FALCON FAMILY EYE CARE – SITE DEVELOPMENT PLAN

PROJECT ADDRESS: 7615 McLaughlin Rd, Peyton, CO 80831

Letter of Intent_V1.pdf Markup Summary

FALCON FAMILY EYE CARE
7615 McLAUGHLIN ROAD
DEVELOPED CONDITIONS MAP
PEYTON, COLORADO

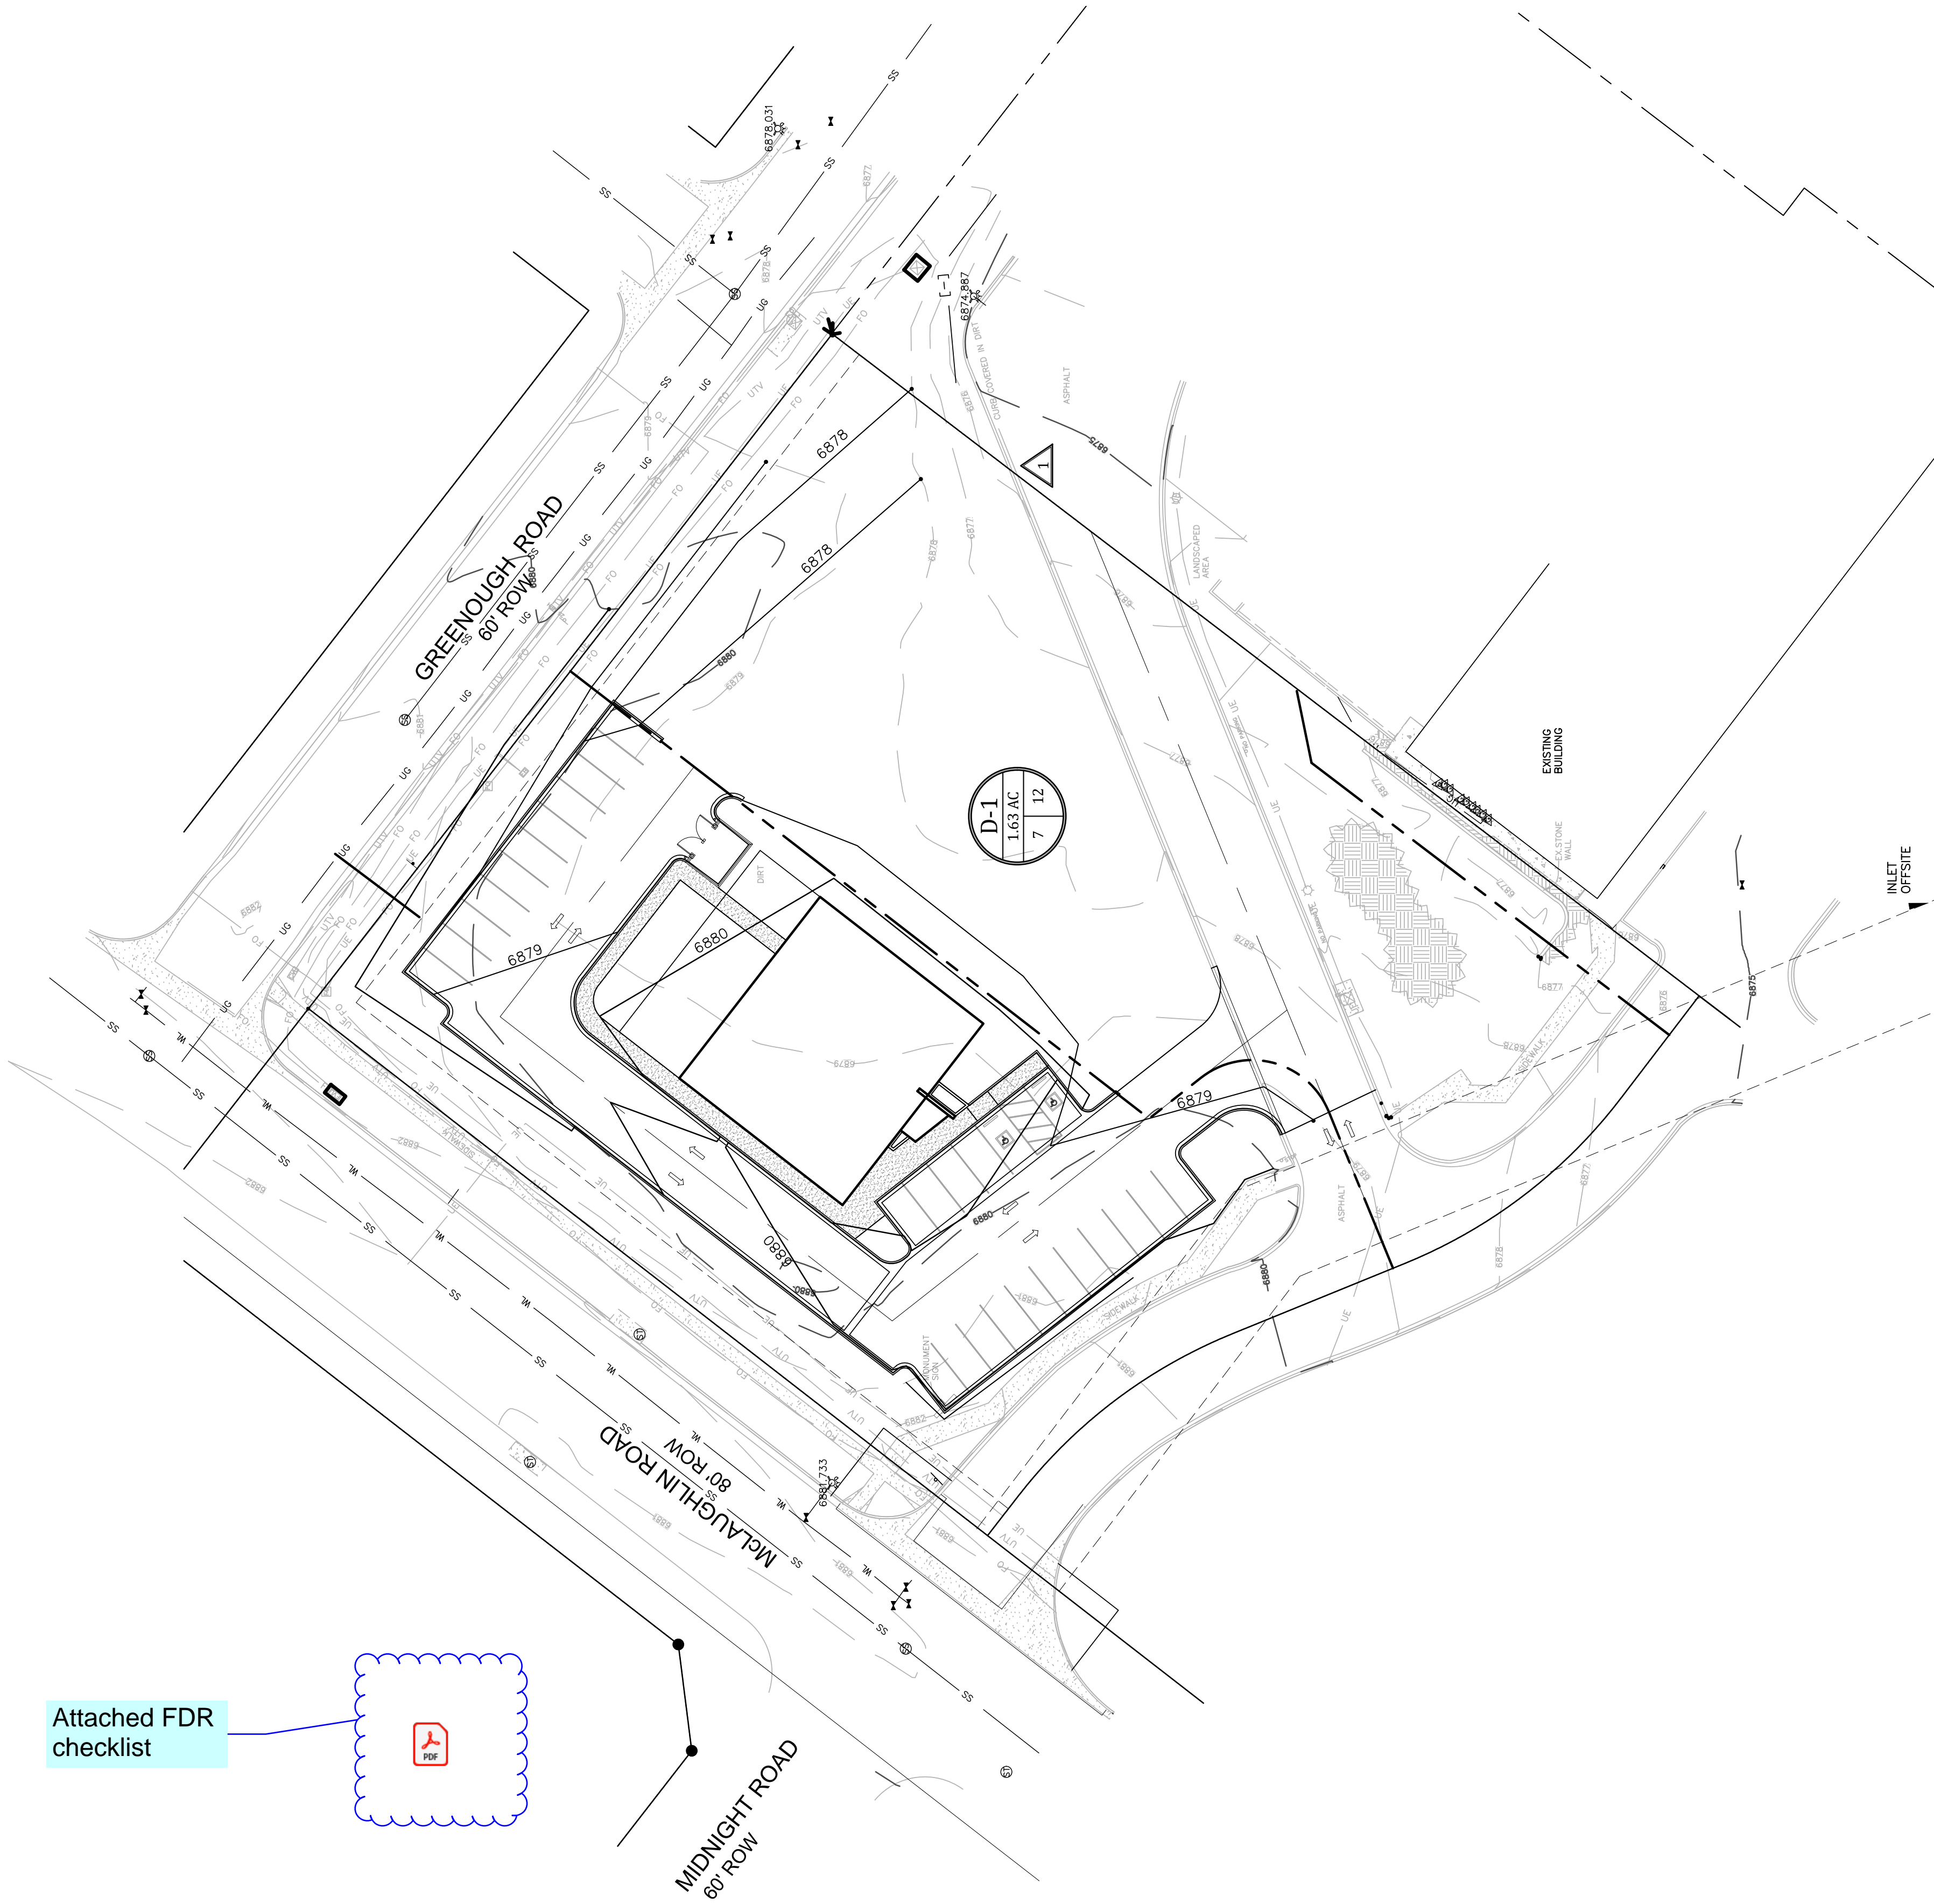
Please provide written documentation/agreement with the neighboring property owner (to the east) to allow stormwater to be discharged onto their site.
